RE: SSD-83258708 - 29 Florida Street, Sylvania – Response to Submissions – Waste Management

MRA Consulting Group (MRA) was engaged by the NSW Land and Housing Corporation to prepare a waste management plan (WMP) to support the proposed State Significant Development (SSD-83258708) for the Construction of 8 residential flat buildings containing a total of 484 dwellings across two stages (including 159 residential apartments for the purpose of affordable housing).

This response has been prepared in response to the Department of Planning, Housing and Infrastructure's (DPHI) request for Response to Submissions dated 17 February 2026, specifically to address Sutherland Council's submission to DPHI dated 22 January 2026, which raised issues around waste management. Table 1 outlines issues raised by Sutherland Council and provides

GA - OVERALL - LEVEL 05

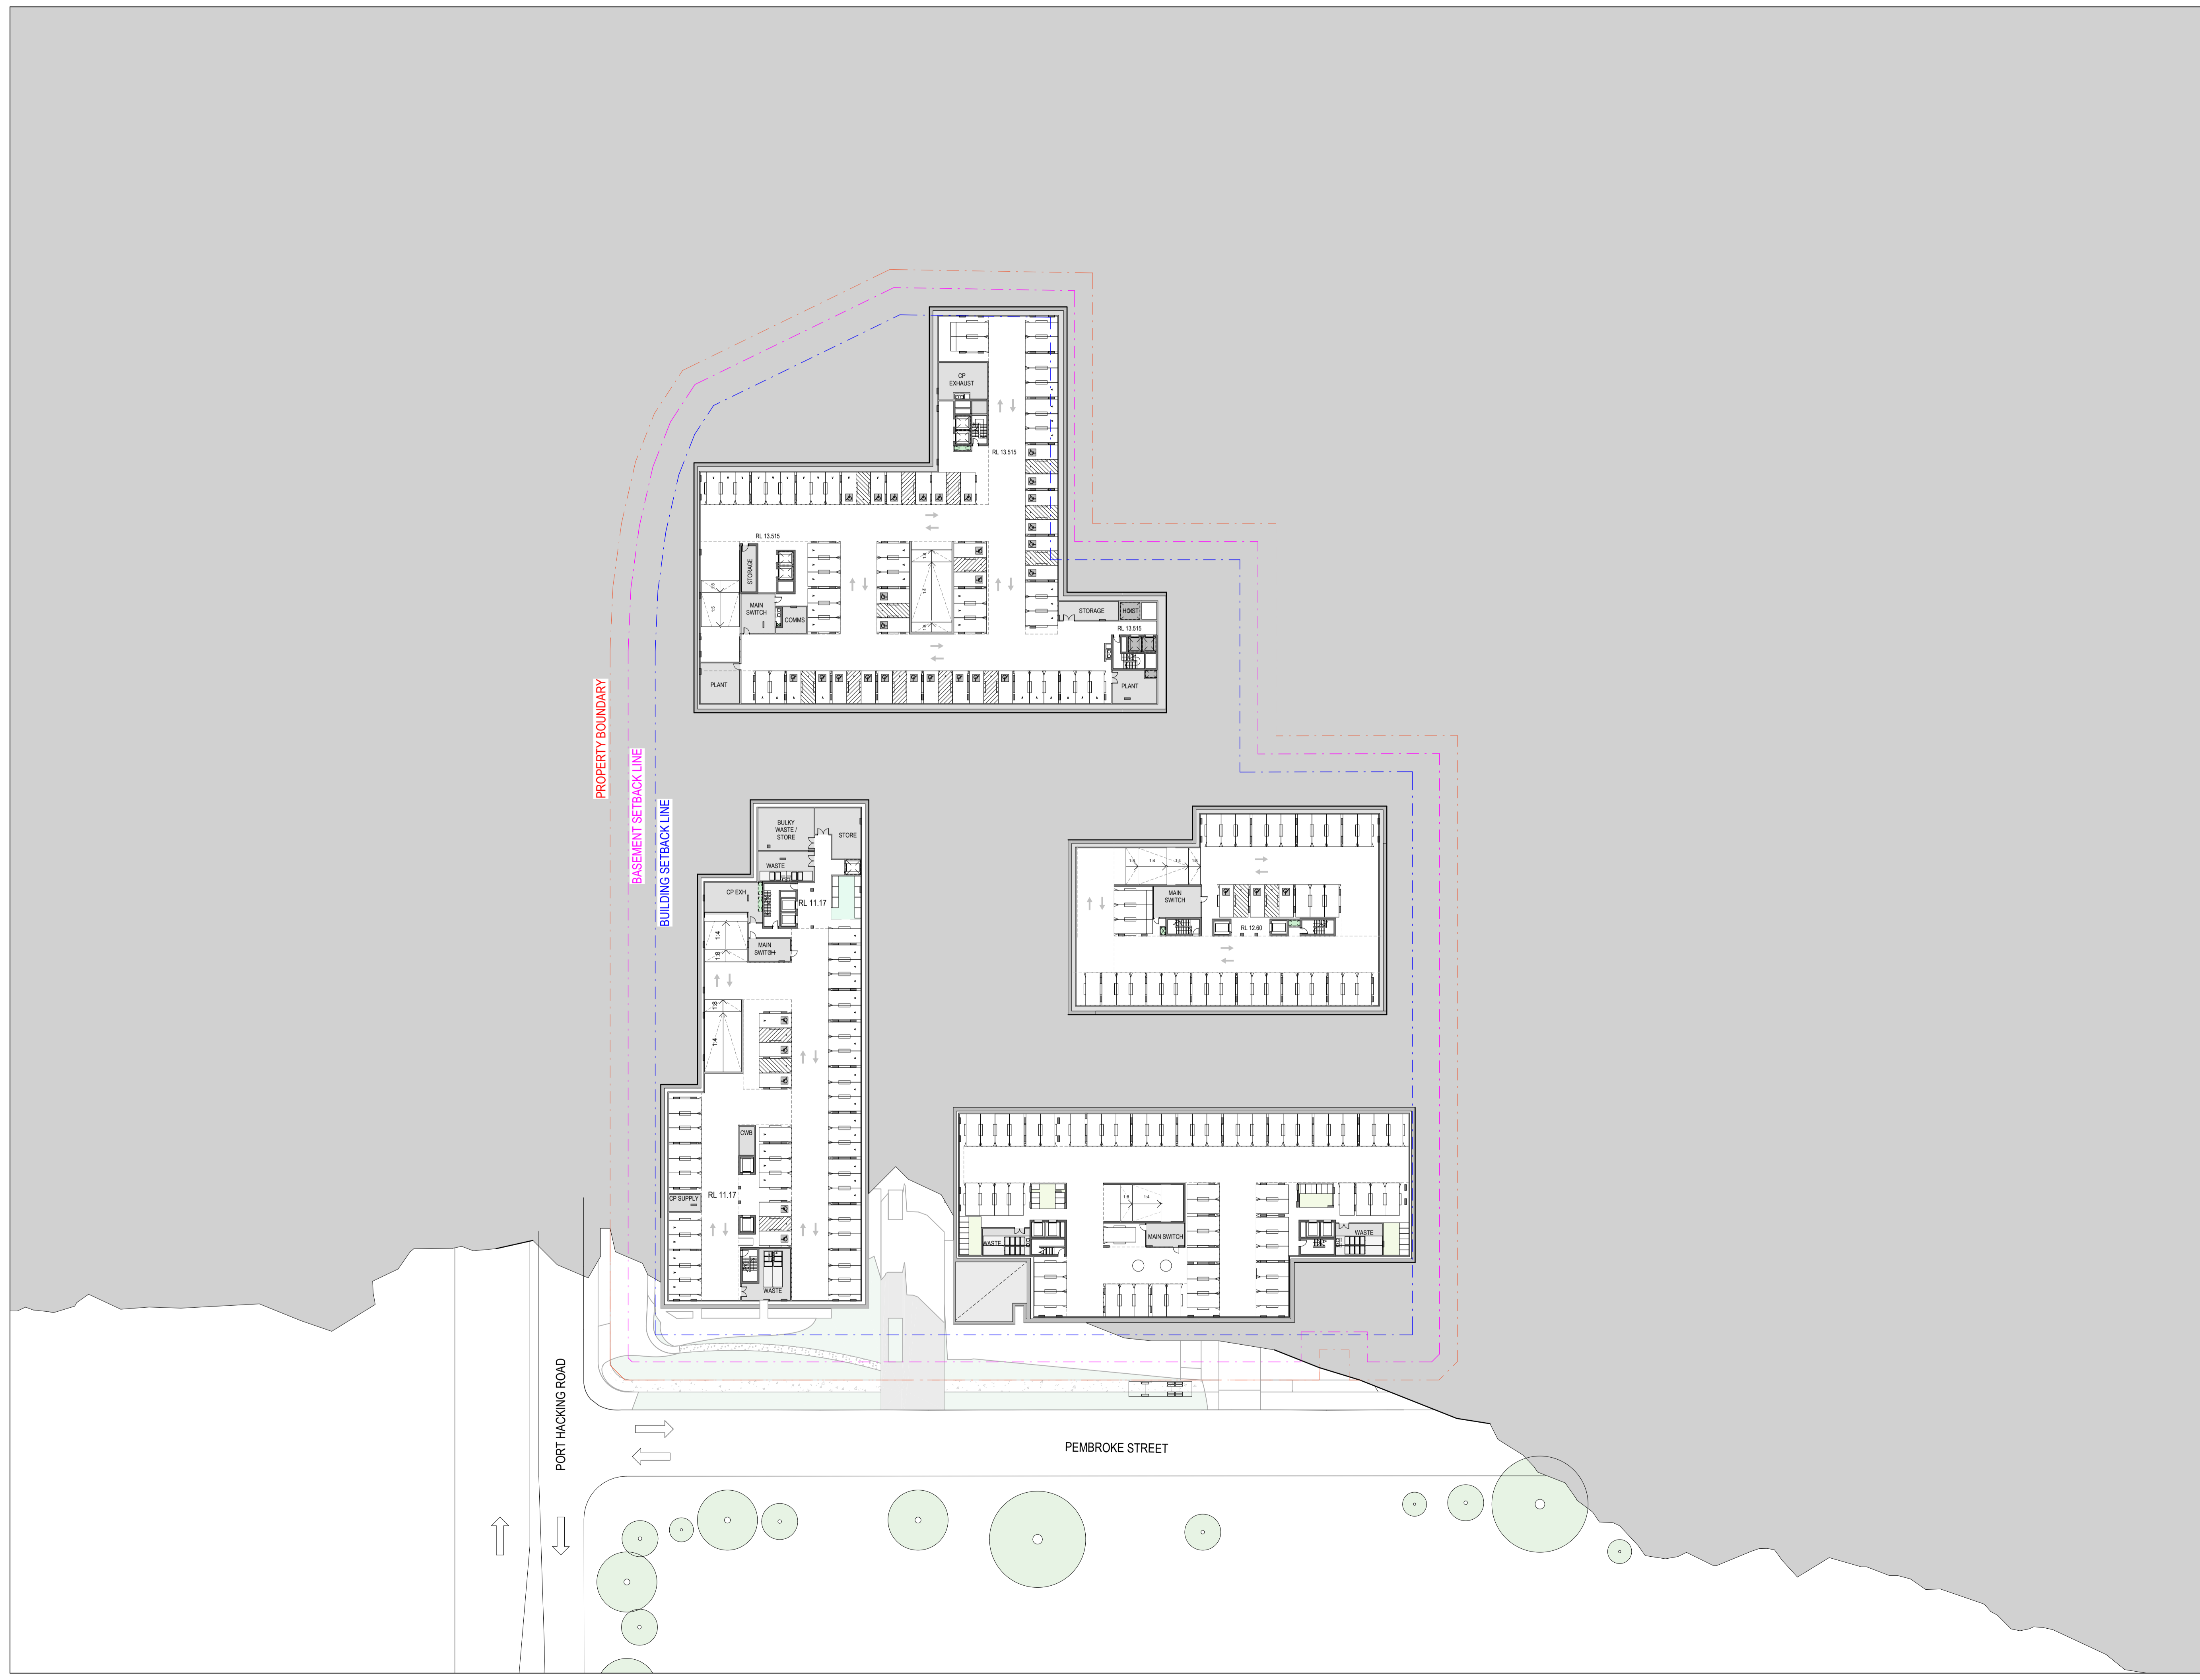
Social housing building • The distance between the truck and bin rooms needs to be less than 10m to ensure the truck can reverse to the door – the distance seems to be greater and is not supported. • The driveway proposed to the waste room fronting Pembroke Street is not long enough to accommodate a parked waste truck. The driveway is required to be lengthened to ensure the public footpath is not obstructed when the truck is parked.	• Due to the setback of the proposed Social Housing building and existing trees being retained between the proposed street and the building, the proposed loading zone is sited as close as possible. It is noted that the travel distance is approximately 12.8m which is a minor exceedance given the constraints outlined. • Plans have been amended to correct a graphical error which showed the waste collection vehicle on the pedestrian pathway.

Item	Response
The bulky waste room is not large enough to accommodate the number of residents within this building. The bulky waste room also needs to be located at the kerbside with a double door or roller door for ease of access.	The bulky waste storage area for the Social Housing building is approximately 22m² in size. This storage area is anticipated to be sufficient for the needs of the Social housing units. Adjusting the location of the bulky waste storage area toward the street would result in the displacement of bin storage that currently occupies the area. In doing so, access to bins for collection which would be on a more regular basis compared to bulky waste, would be compromised. As an alternative arrangement, bulky waste and bins can be rotated prior to scheduled bulky waste collections to ensure bulky waste material is positioned as close to the front of the waste holding areas as possible.
